Engineers Comments Regarding Surface Water Drainage

Application Reference:	FP/69/26/HH	Reviewer Reference:	ADC/EXT5/AF
Planning Officer:	Silvie Steininggerova	Date of Review:	30/06/2026
Site Name:	2 Ceres Place Felpham PO22 7RG		
Application Description:	Demolition of existing conservatory. Construction of two storey and part single storey rear extension.		
Assessment Number:	1

Proposed Block Plan

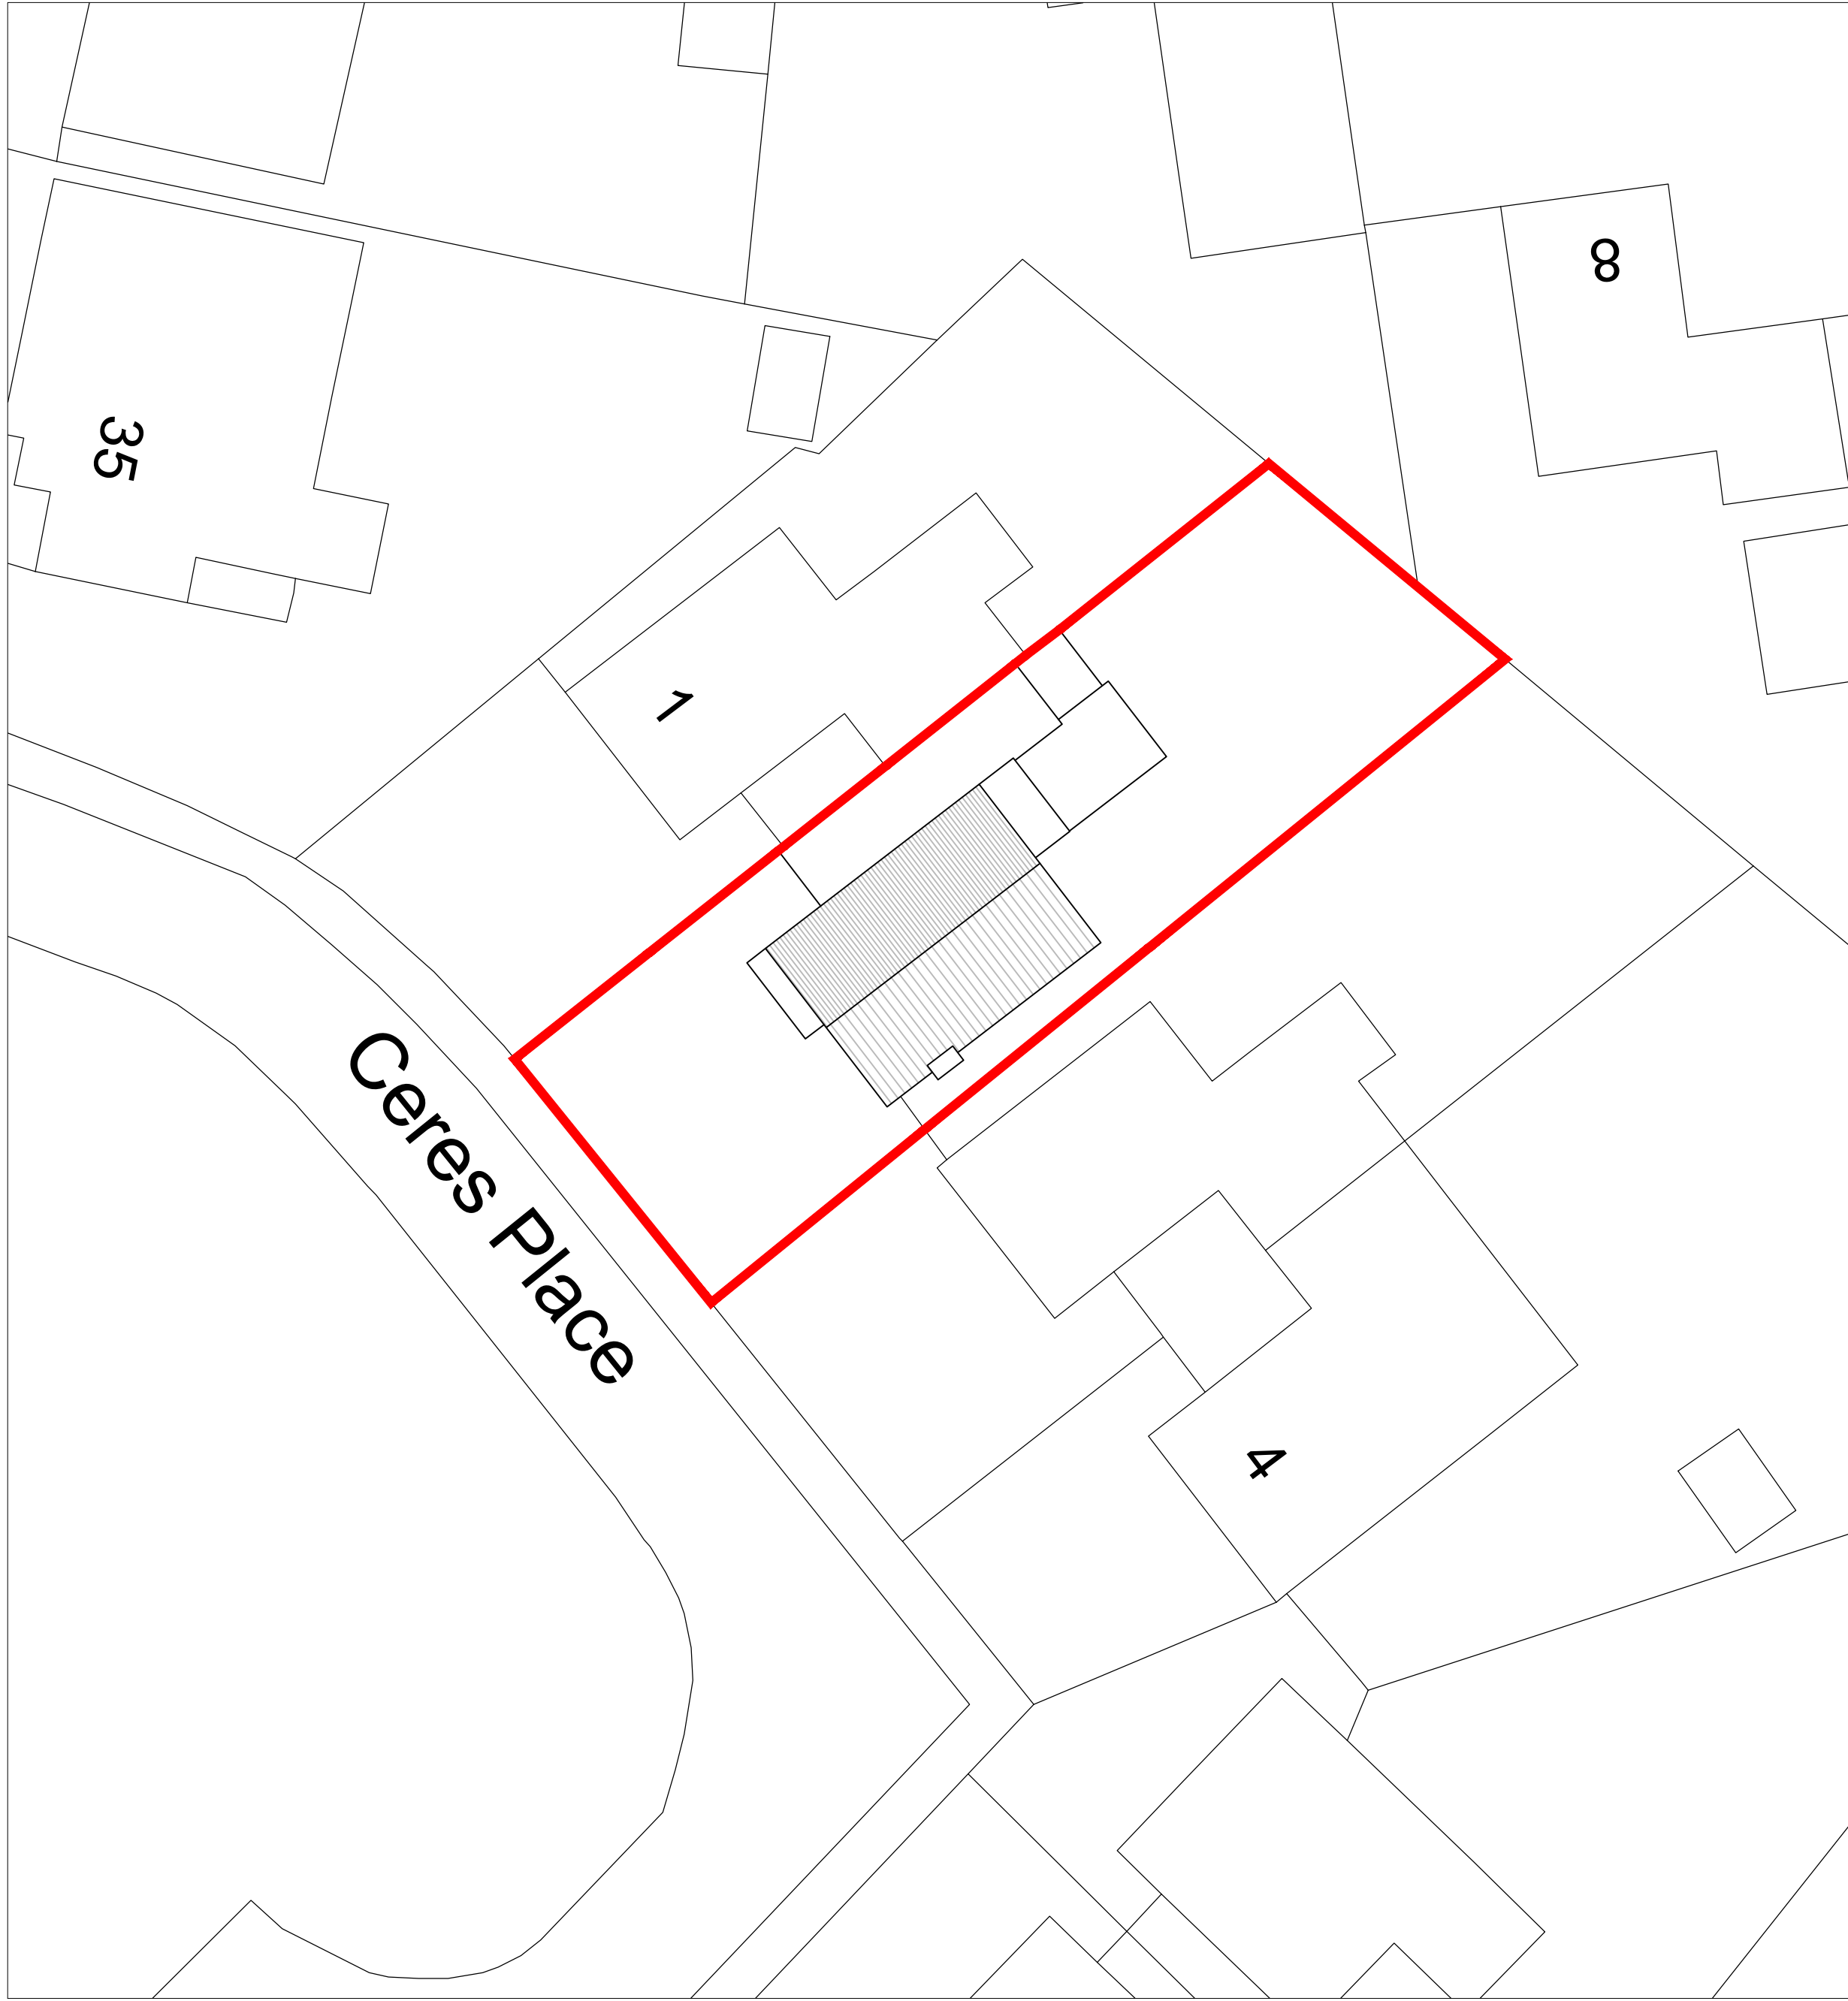
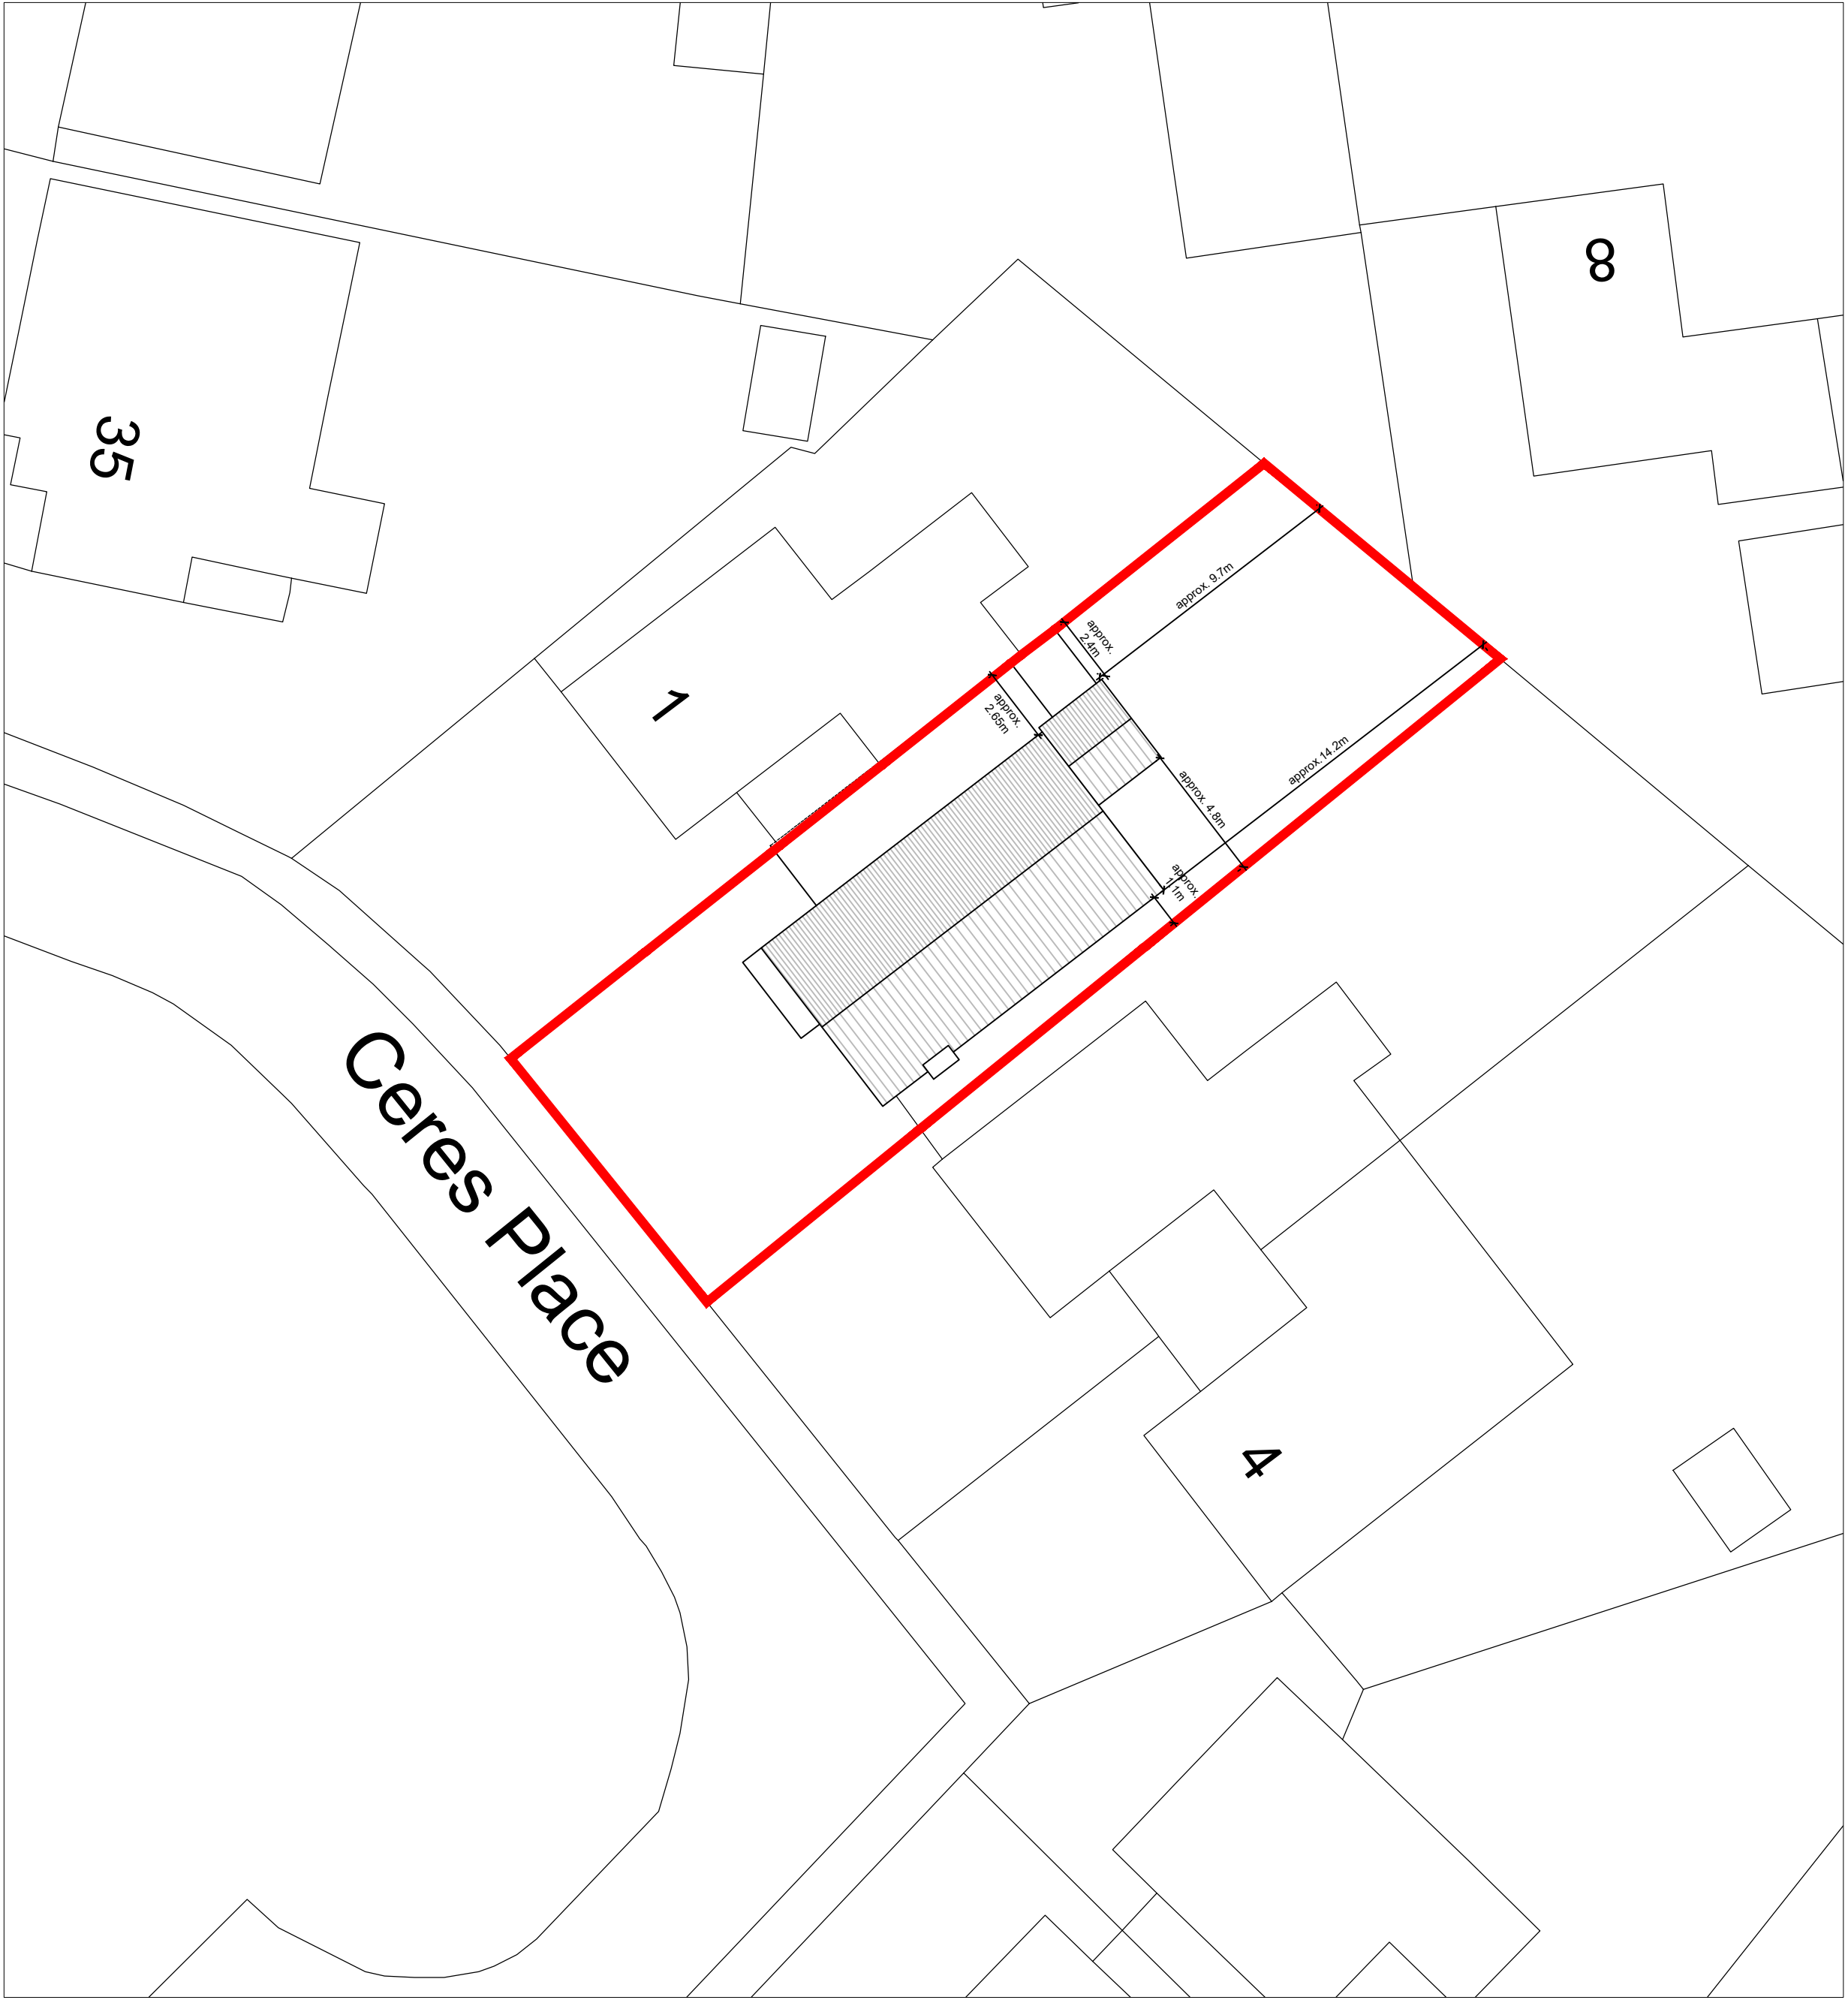
- 3.1. No calculations are provided for the drainage system. The additional area should be attenuated, or the infiltration feature sized to accommodate large return period storms.
- 3.2. The drained area should be clarified and runoff calculated for the design storm based upon up to date rainfall data. Guidance is provided on ADC webpages - <https://www.arun.gov.uk/surfacewater>.
- 3.3. Management of extreme rainfall is not currently in accordance with the requirements of the NSfS Standard 3. Therefore, we **object** to the application.

- 4.1. No assessment for water quality is provided with the application and water quality mitigation is not currently incorporated into the design.
- 4.2. However, there is no new trafficked areas shown on the layout and measures to mitigate runoff from roof areas and paths are likely to be able to be integrated at technical design stage.
